SUBJECT: **BRES2507-0005**
BUILDING RESIDENTIAL

Here are the results of all Inspections located at **47 EAGLE CREST CT:**

Result: DISAPPROVED

47 Eagle Crest Ct
Hillington NC

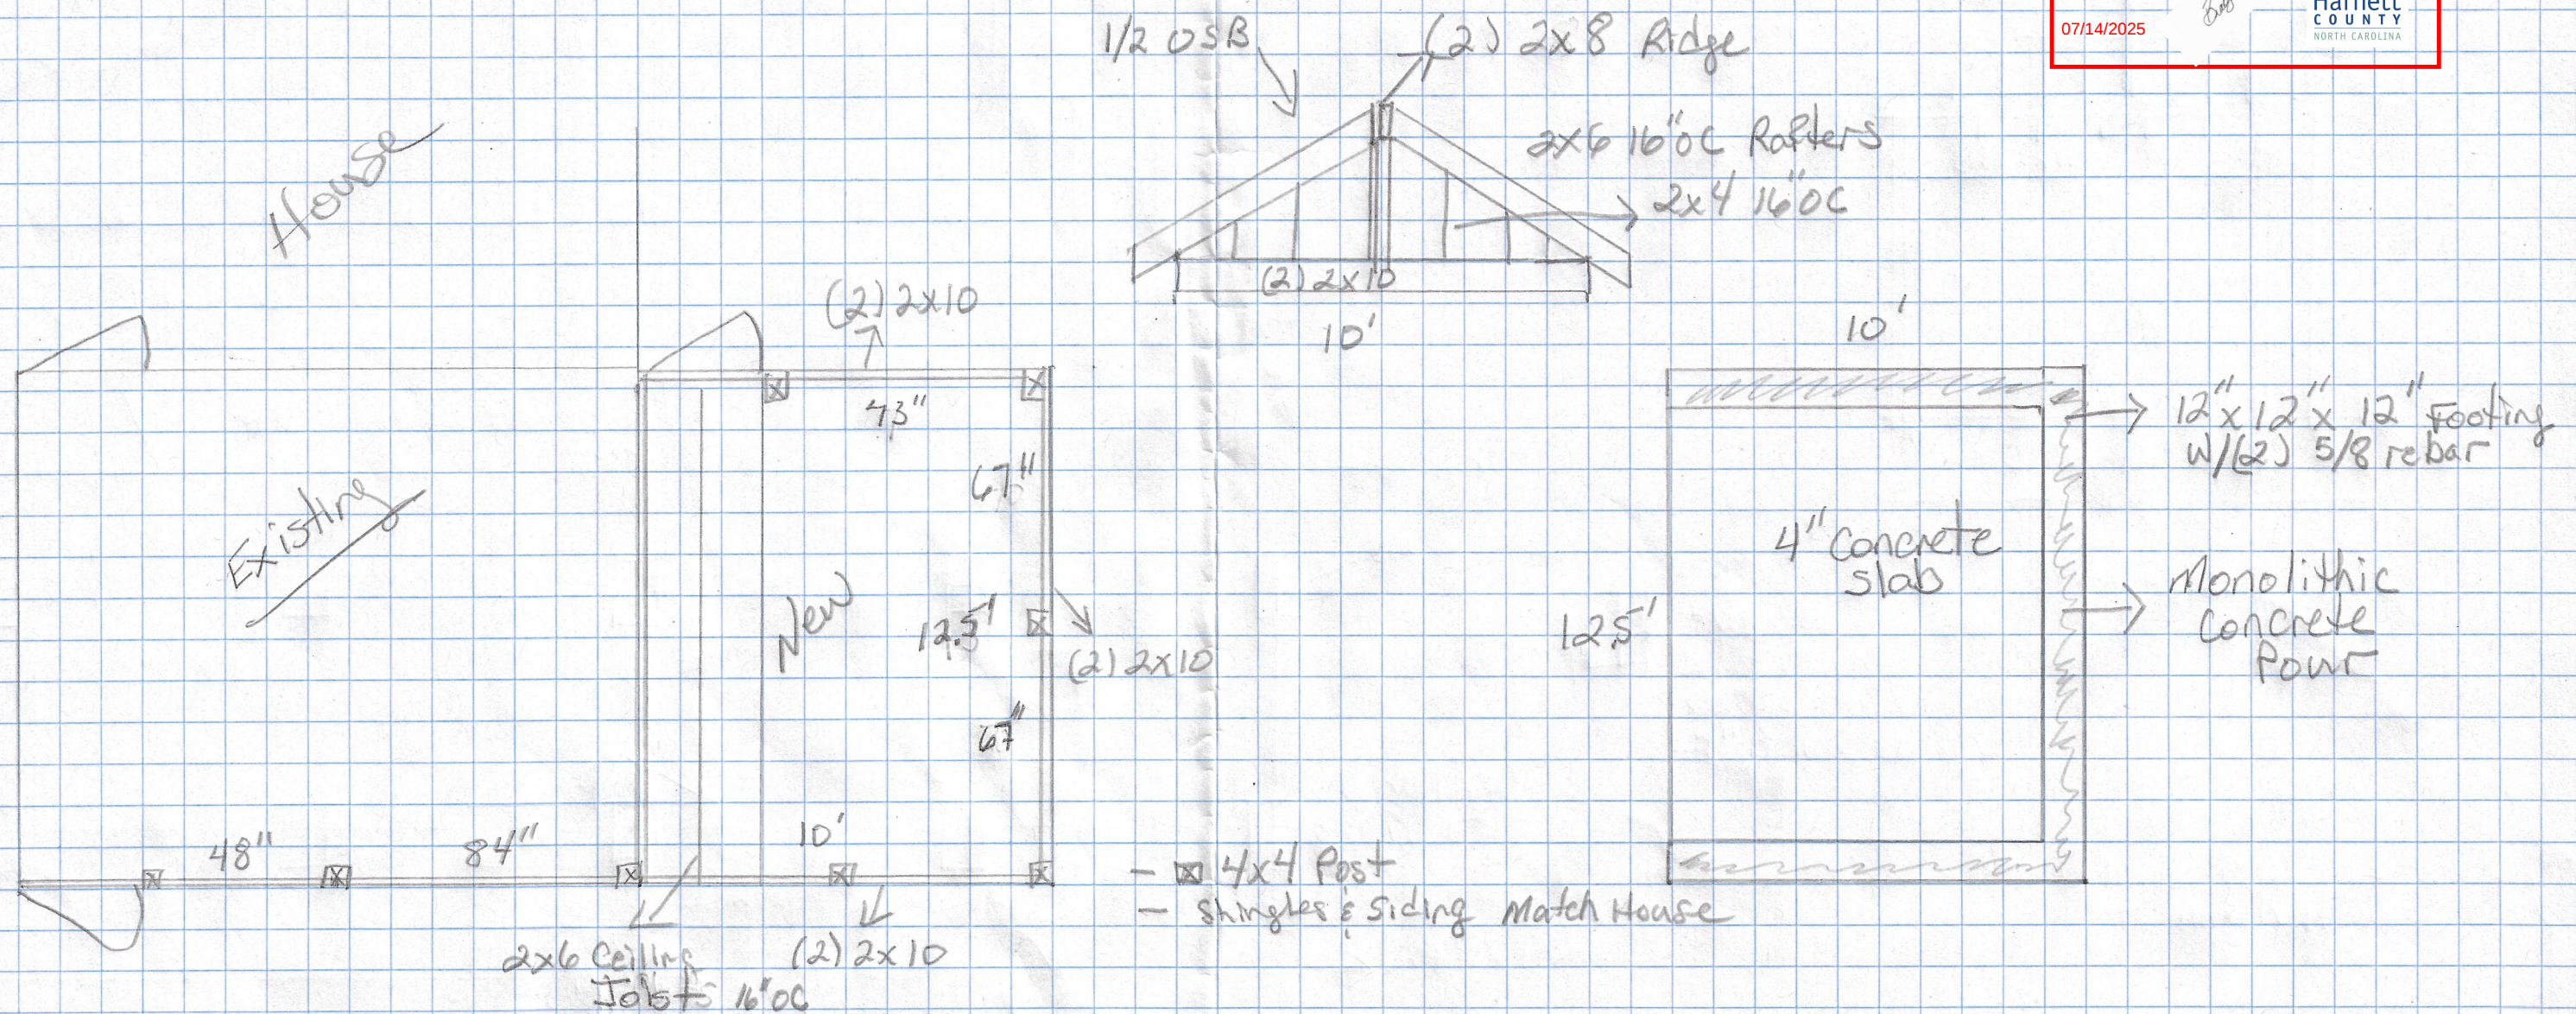
Notes: Footings not deep enough. Bottom of footings must be 12" minimum below grade.
